RE: Simmons Short Plat SP-11-00008

Thank you for the opportunity to comment on the Simmons Short Plat, SP-11-00008.

**Review of the Application File:**

KITITAS COUNTY SHORT PLAT

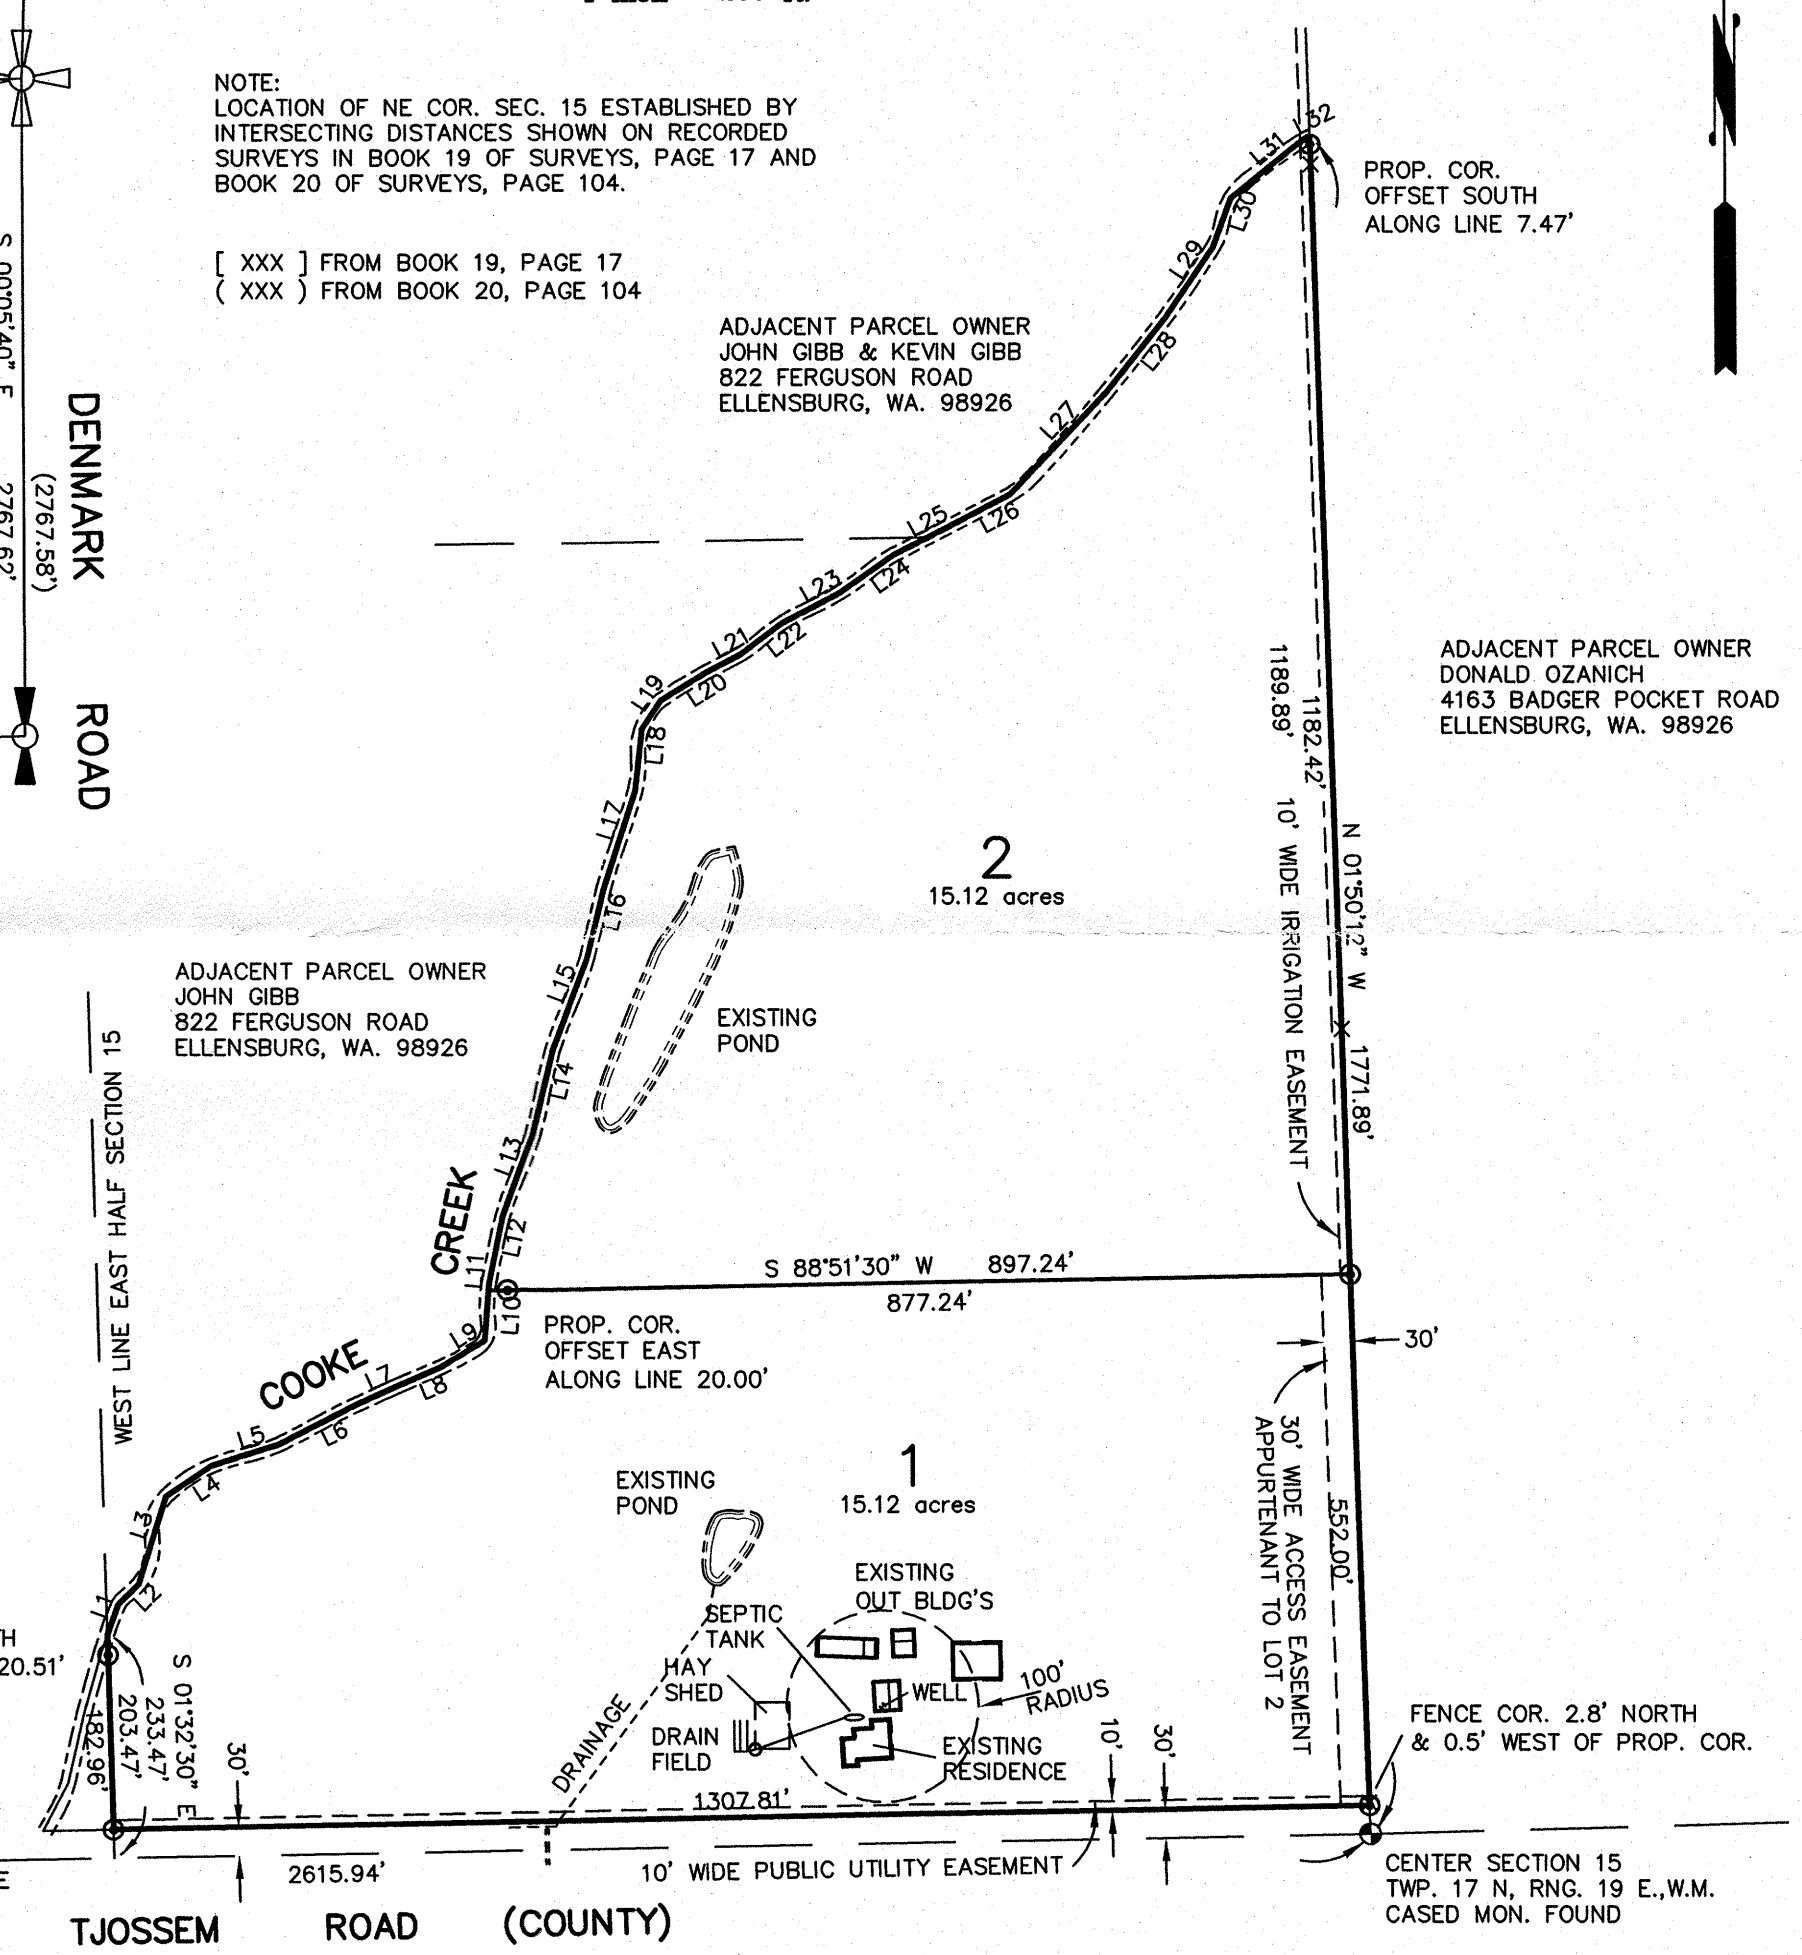
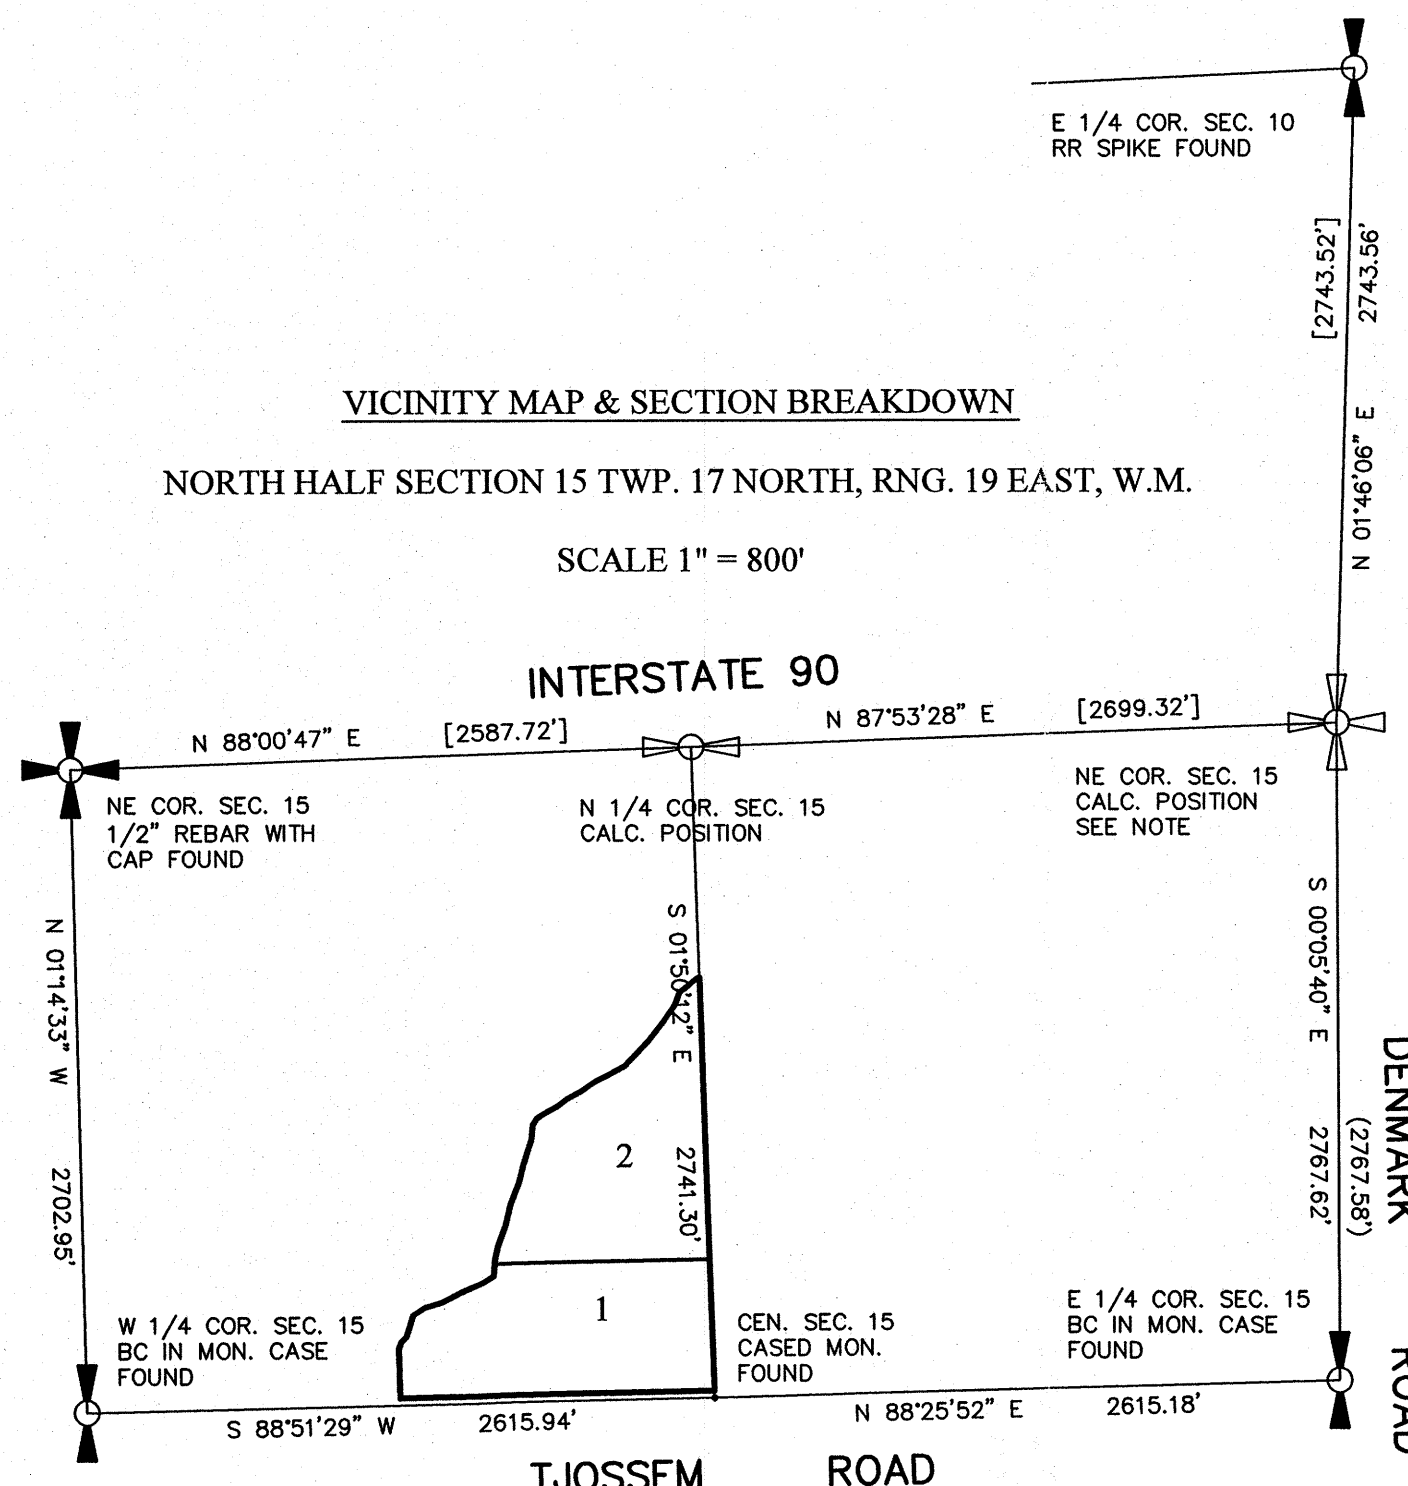
At this point in time this application does not contain sufficient information to make a determination that there is an adequate potable water supply available and soil logs have not been conducted to verify soil conditions for on-site sewage systems. The above mentioned requirements needs to be satisfied and the appropriate documentation needs to be submitted to the Public Health Department for review and approval in order for the plat application to be recommended for final approval.

**In addition to this information our office is requesting additional information regarding the septic system(s) currently on site. Our department would like to know the type, size, age, location on site and the distance to any septic tank or drainfield(s) and the existing well. Depending on the circumstances our office may have additional requirements.**
